Submission by Mallard Pass Action Group (MPAG)

Deadline 9:

**Comments on the Applicant's
Responses (REP8-019) at D8
to D7 submissions
of Interested Parties**

Plate 7: Typical PV Array

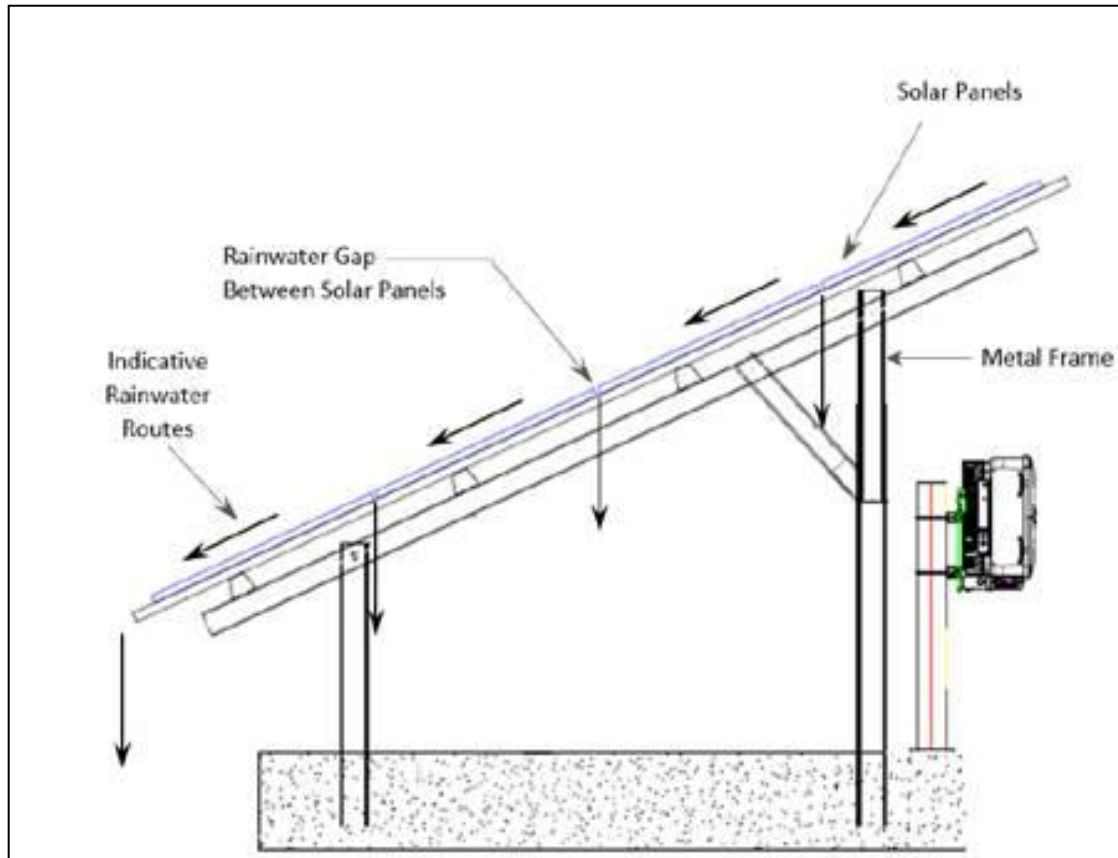
<p>River in a short period of time, inevitably increasing river levels & the risk of flooding in Greatford. But no, according to MP this can be reduced to a 0% increase by 4 measures;</p> <ul style="list-style-type: none"> - As shown in plate 7 MP intends to leave gaps between the frame-mounted panels rather than a single drip line at the lowest end. Their reasoning seems to rely upon a report by Cooke & McEwan which in summary, states ' solar panels do not have a significant effect on run off volumes or peak flows however where ground beneath panels is bare there may be an increase. MP, however make no reference to the conclusion in this report which states that in certain circumstances, the peak discharge could be in excess of 100%, which of course, would be a major problem! - MP are relying upon clay soils across the site not being compacted during the construction period & that grass can be established both under & between panels. This is referenced in Natural England's technical information note 101 which says ' the key to avoiding increased runoff & soil into water courses is to maintain soil permeability & vegetative cover. Permeable land surfaces underneath & between panels should be able to absorb rainfall as long as they are not compacted & there is vegetation to bind the soil surface. 	<p>It should be noted that the Applicant has updated Appendix 5.1 (submitted at Deadline 5) to include a parameter that limits the surface area of panels to 1,647,300 m². Based on the confirmed PV area, the theoretical surface water increase (assuming PVs on the ground rather than on a racking system) would be a 90 %. Therefore, the calculations presented in Table 7 of Section 3.1 of Appendix 11.6 are an extremely conservative scenario.</p> <p>The raised nature of PV Arrays will not prevent soil from absorbing rainwater as the panels will not be placed directly on the ground and each PV Row will be separated, with the same area of soil available for infiltration as per the baseline scenario. Therefore, the calculated increase does not represent the impact of the PV Arrays on surface water runoff.</p> <p>The Applicant has explained how the Proposed Development is likely to lead to reduced surface water run-off rates compared to the baseline agricultural scenario in its answer to Q12.0.6 a) in the Applicant's Responses to ExA's First Written Questions [REP2-037], principally through the implementation of advanced sowing of grass, where appropriate, in addition to planting and vegetation. This approach has been utilised on other solar developments of similar scale and the methodology has been reviewed by the relevant regulatory bodies.</p> <p>The conclusion of the Cook & McCuen study states that "when gravel or pavement was placed under the panels, with the spacer section left as patchy grass or bare ground, the volume of the runoff increased</p>
